Ref: 6/2017/2622/LB
Date: 24/01/2018

HISTORIC BUILDINGS AND CONSERVATION ADVICE

RE: St. Ethelreda's Church Hall, Church Street, Hatfield, AL9 5AR

DRAWING TITLE
DISABLED LIFT INSTALLATION ALTERATION DETAILS TO EXISTING STRUCTURE

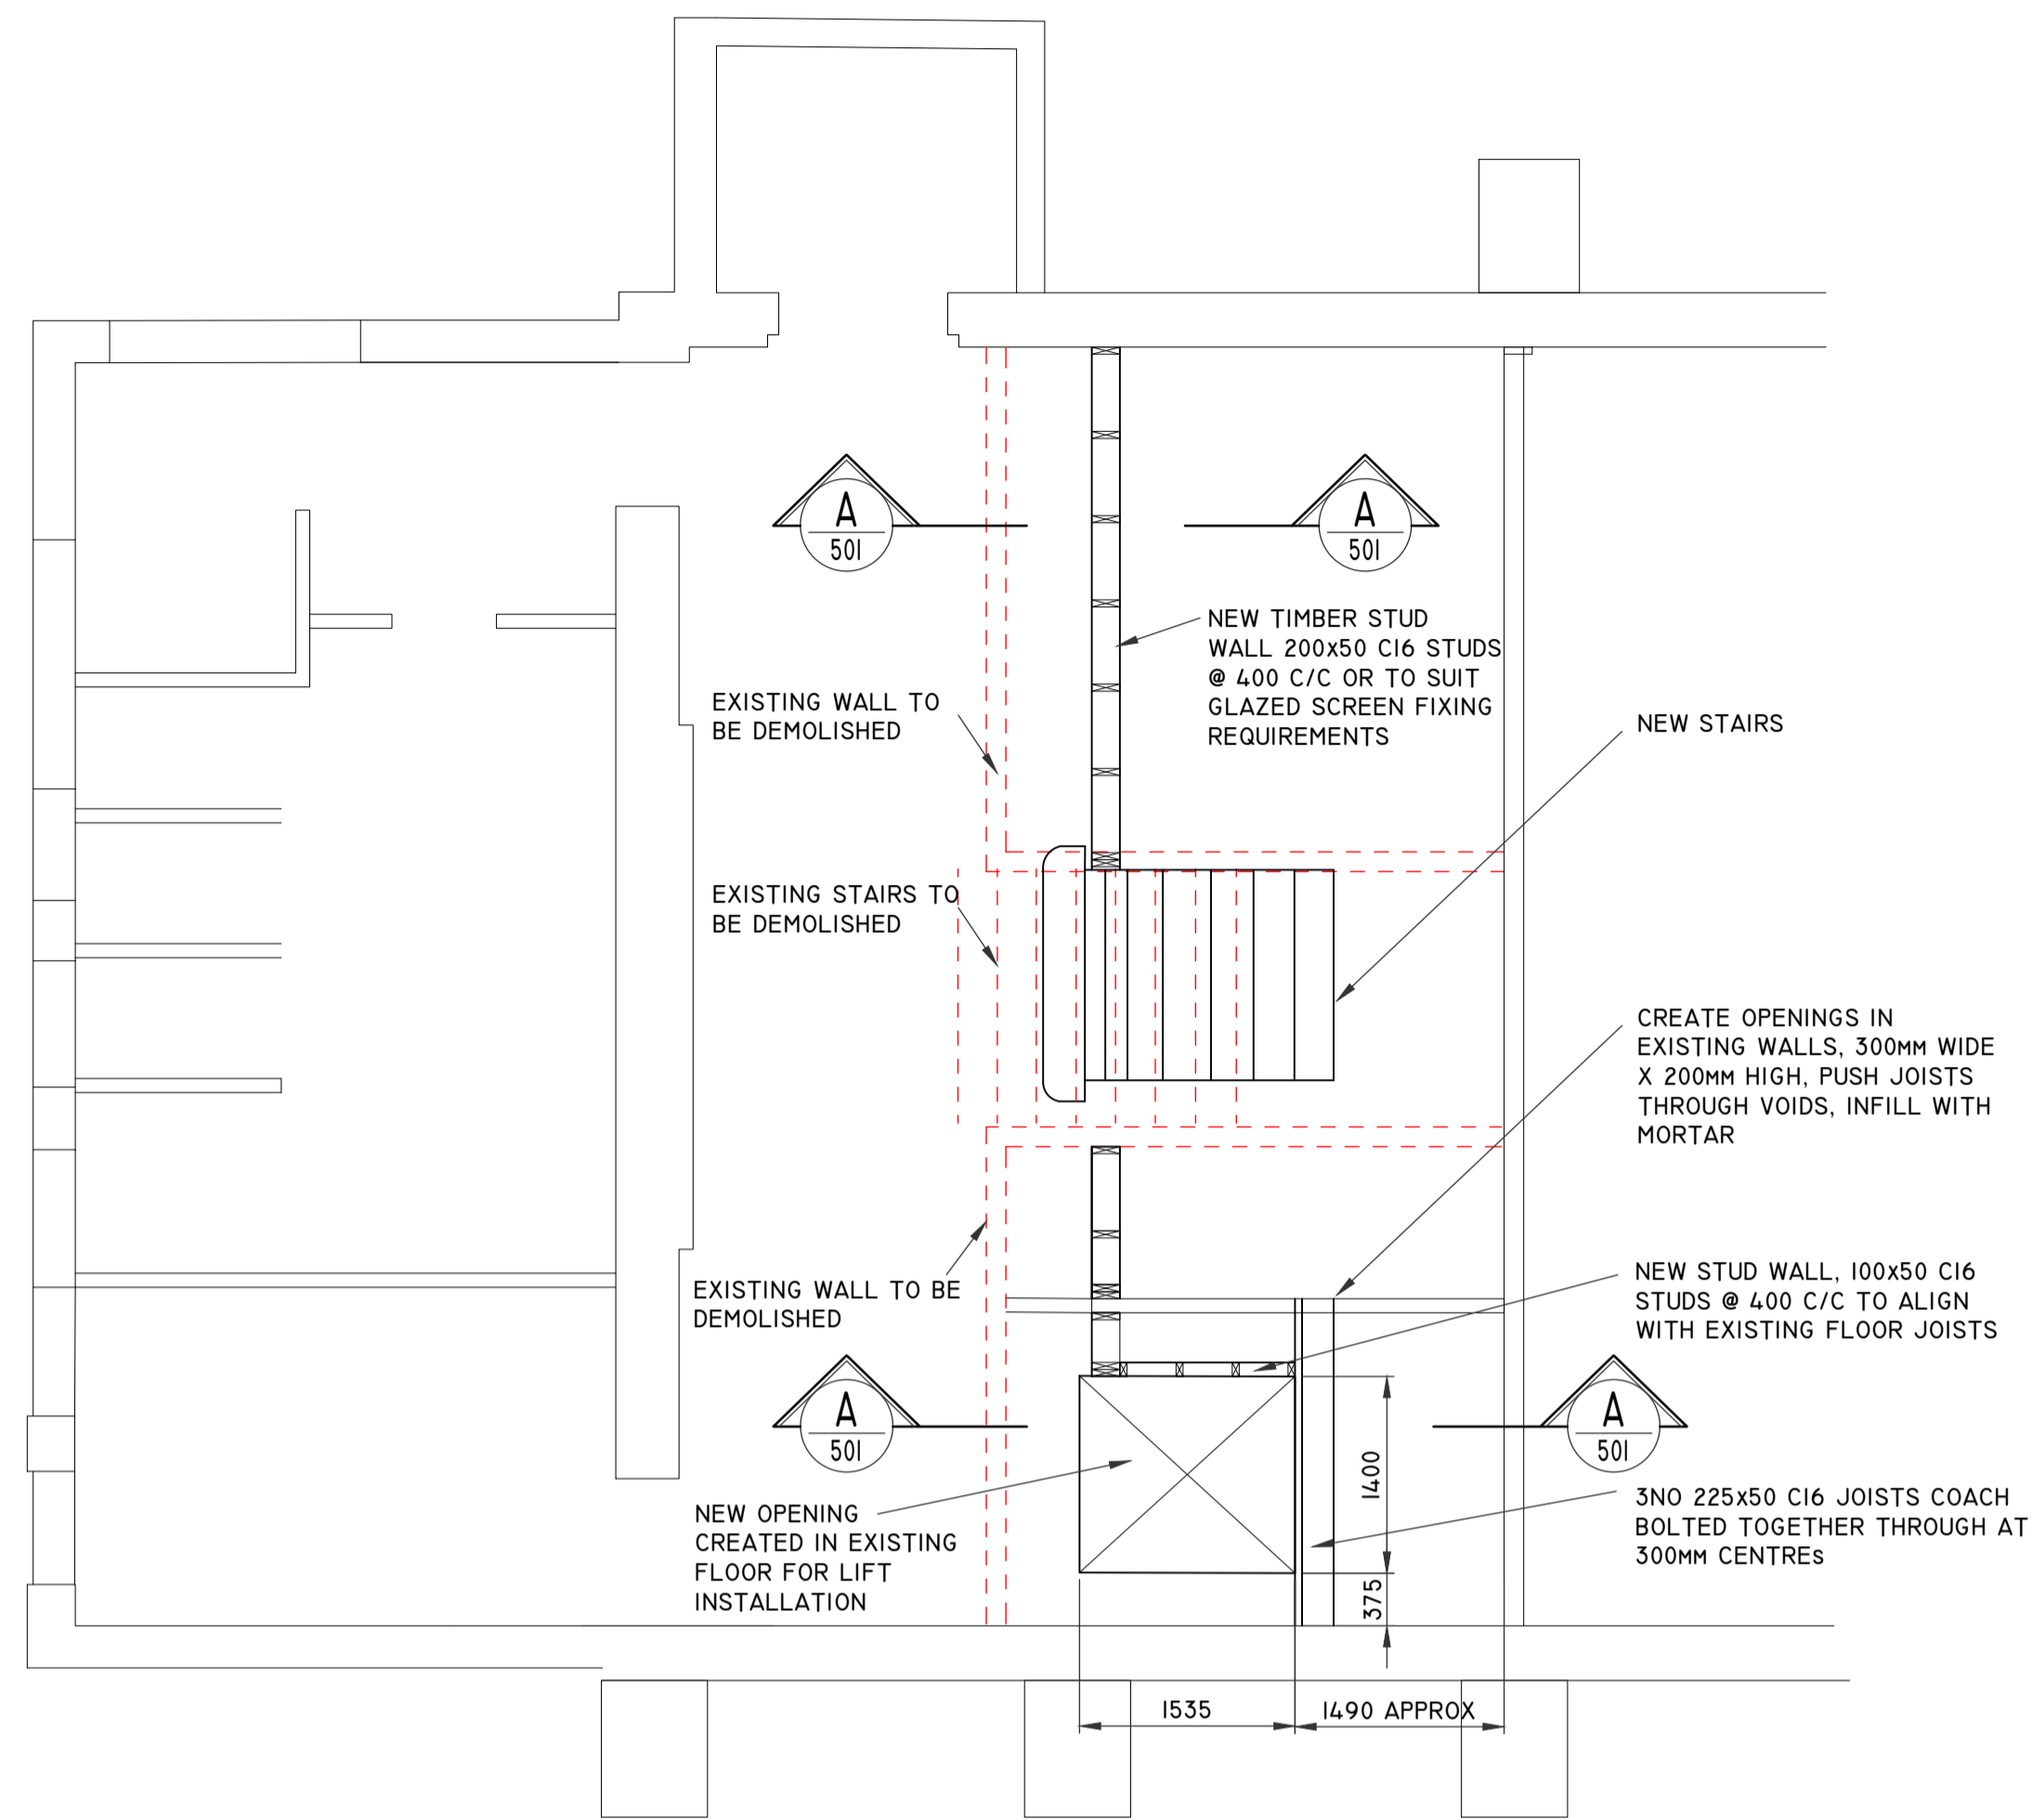
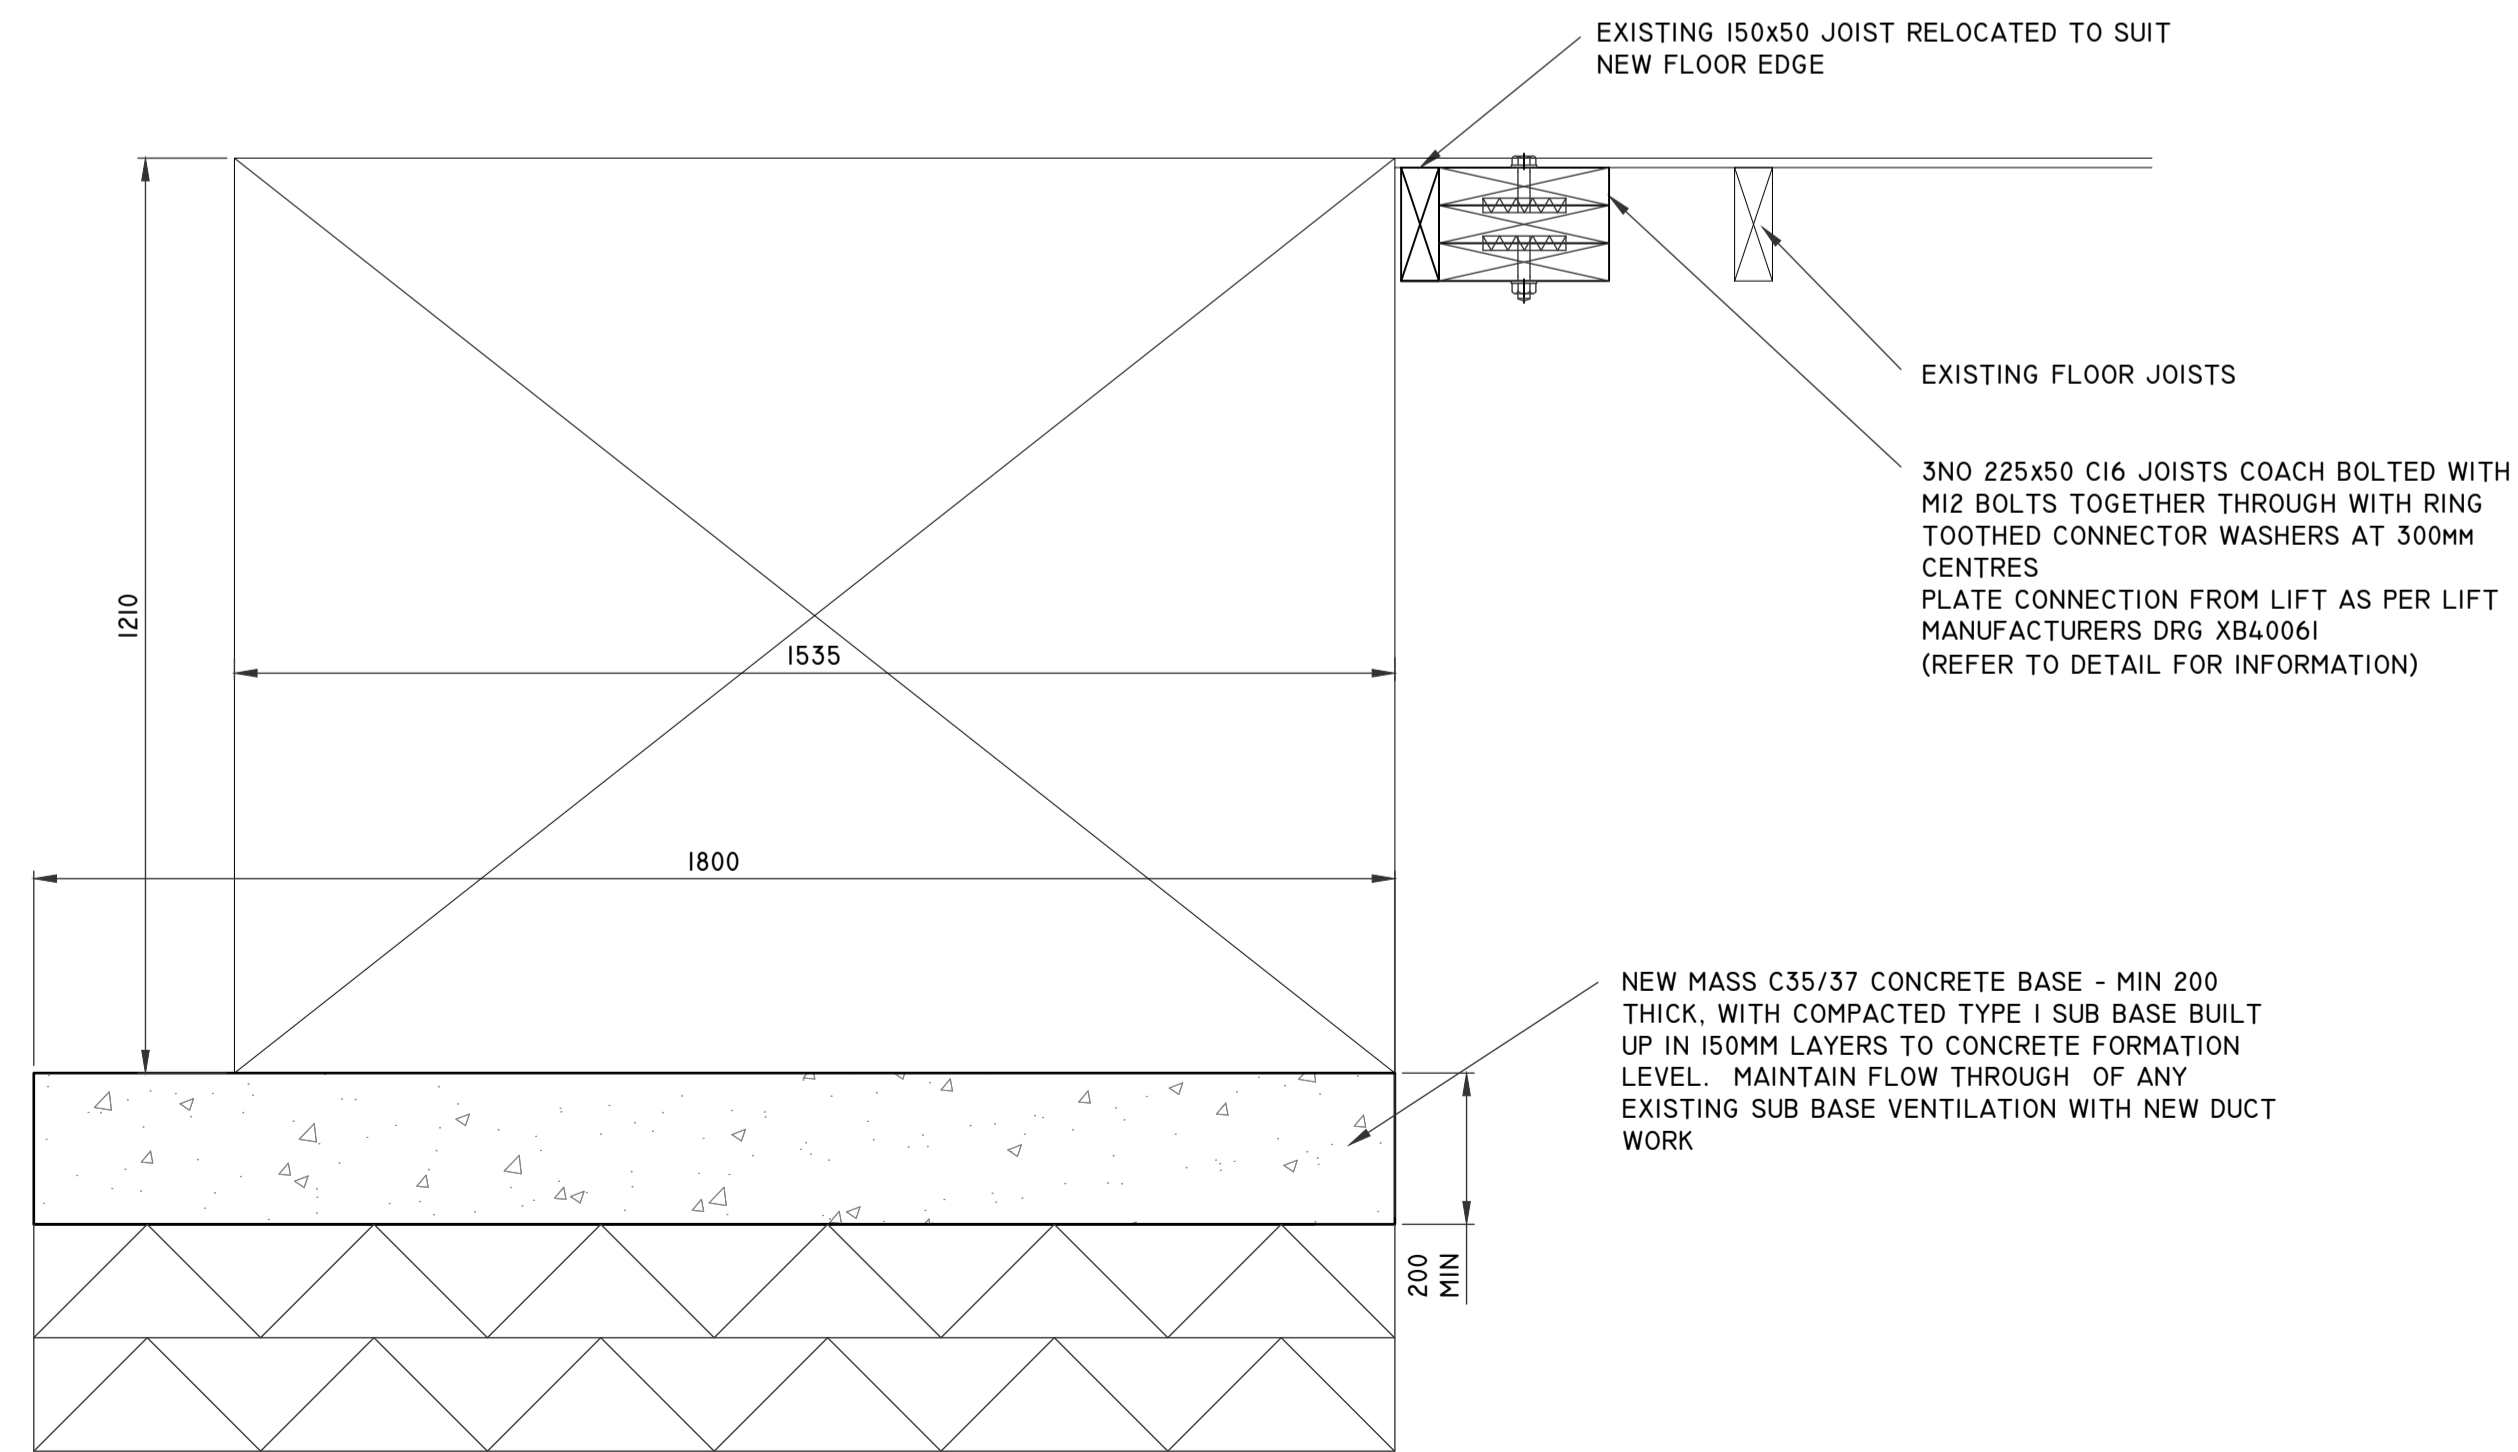
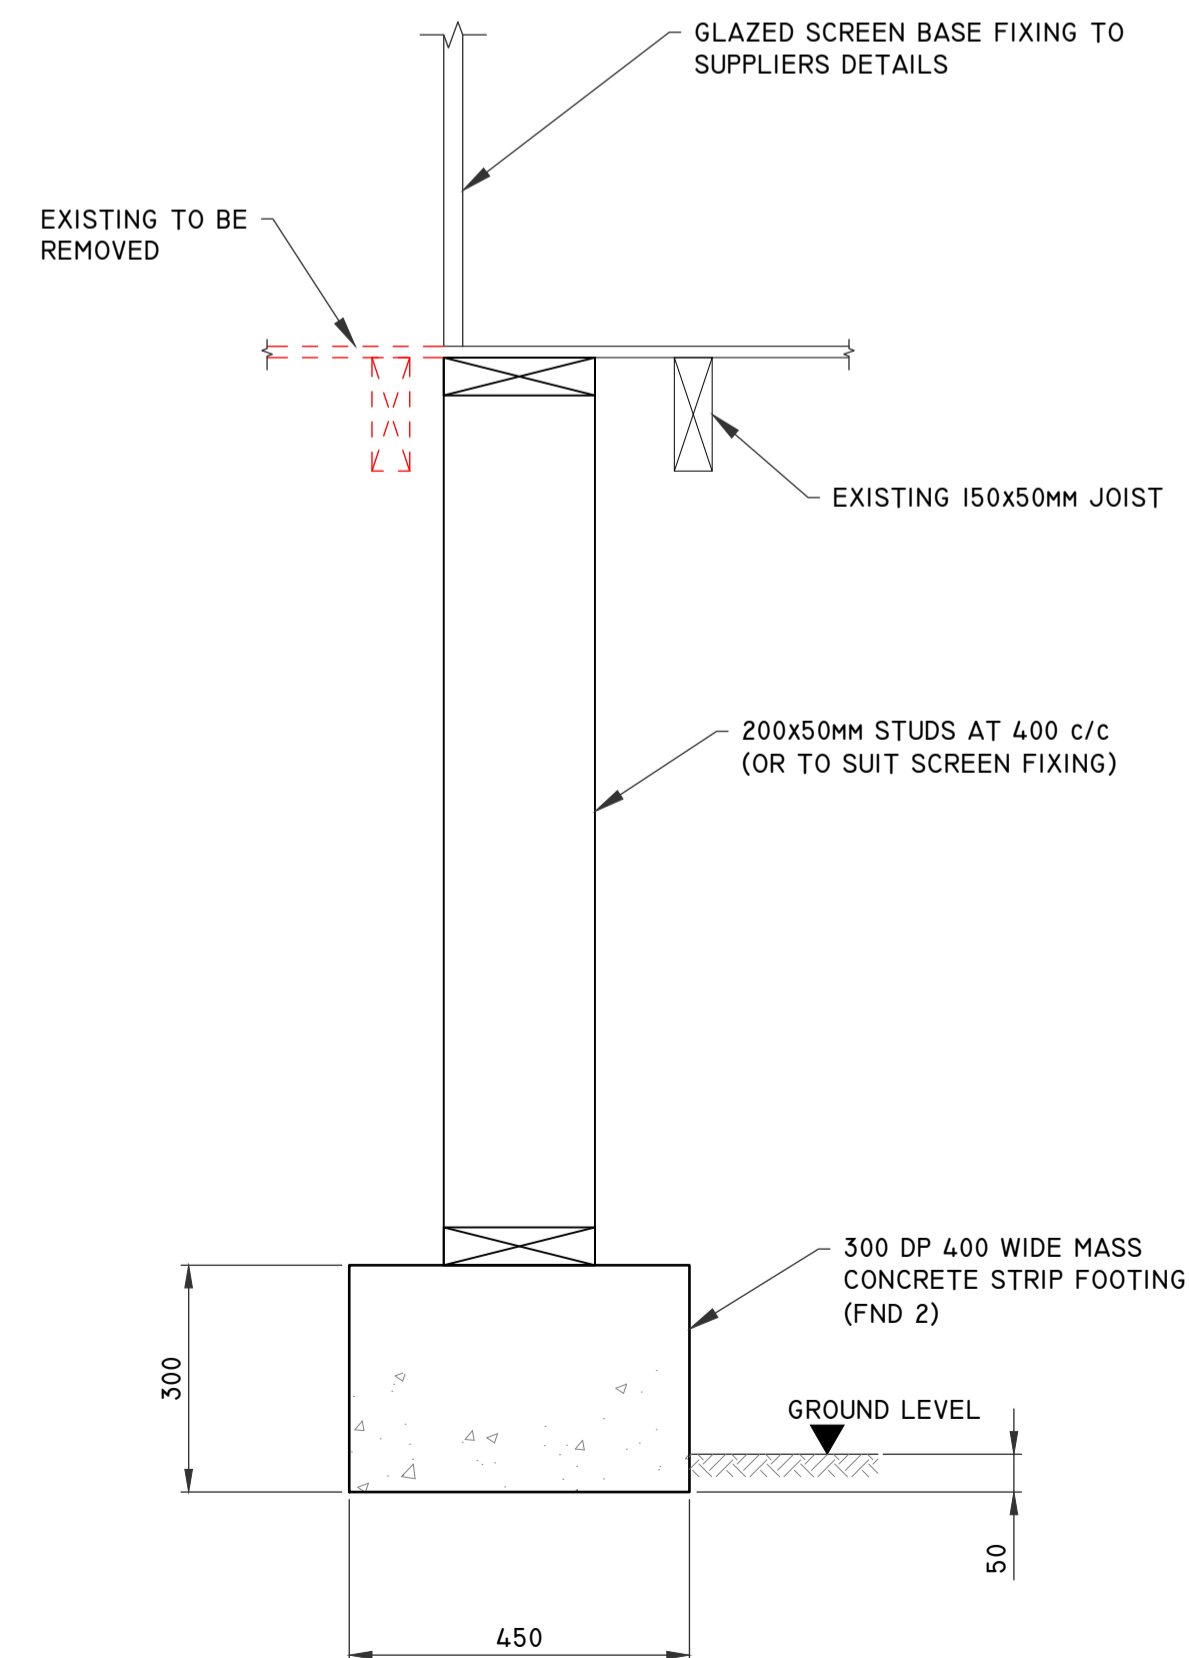
A new hydraulic lift is proposed to be inserted within the floorspace adjacent to the entrance lobby, on the south side of the building, which would likely involve the removal of historic fabric. It is considered, however, that this loss would be minimal and that the proposals would not have a significant impact upon the understanding and appreciation of the special interest of the listed building. The insertion of the lift should however be carefully considered to ensure that it is minimally intrusive to any historic fabric.

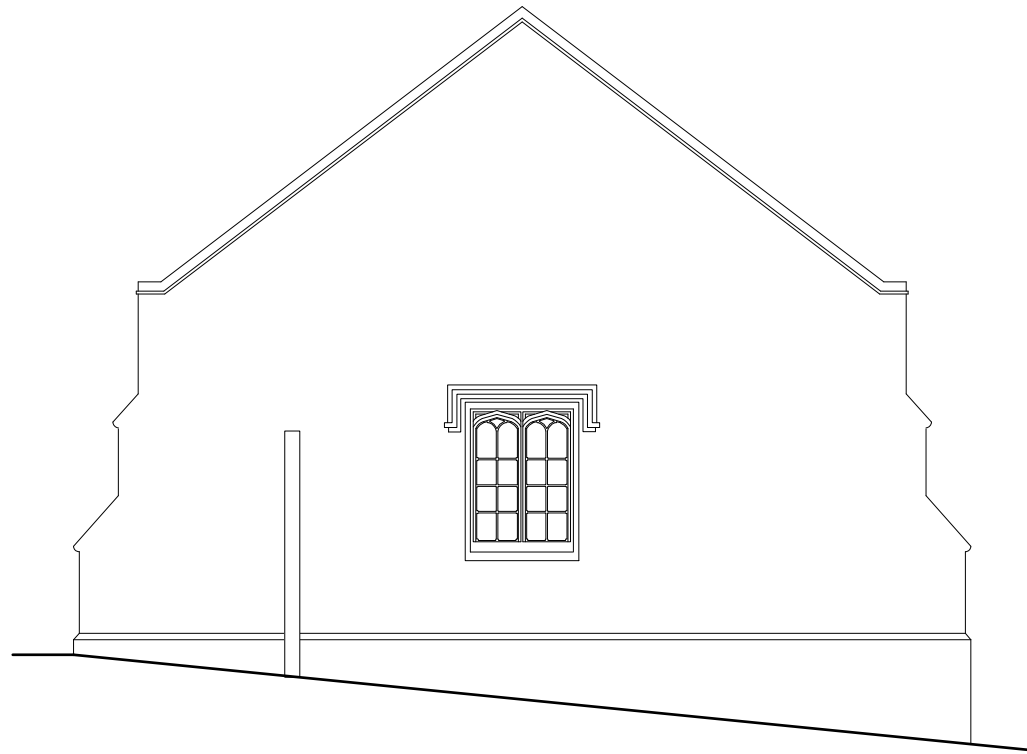
Within the main hall it is proposed to insert new partition walls to create a kitchen and bar 'pod' at the east end of the building. Although this 'pod' would be a reversible addition, it would block views of the window within the east gable of the listed building and would also truncate the volume of the main hall. It is therefore considered that there would be a degree of harm arising from this element of the proposals.
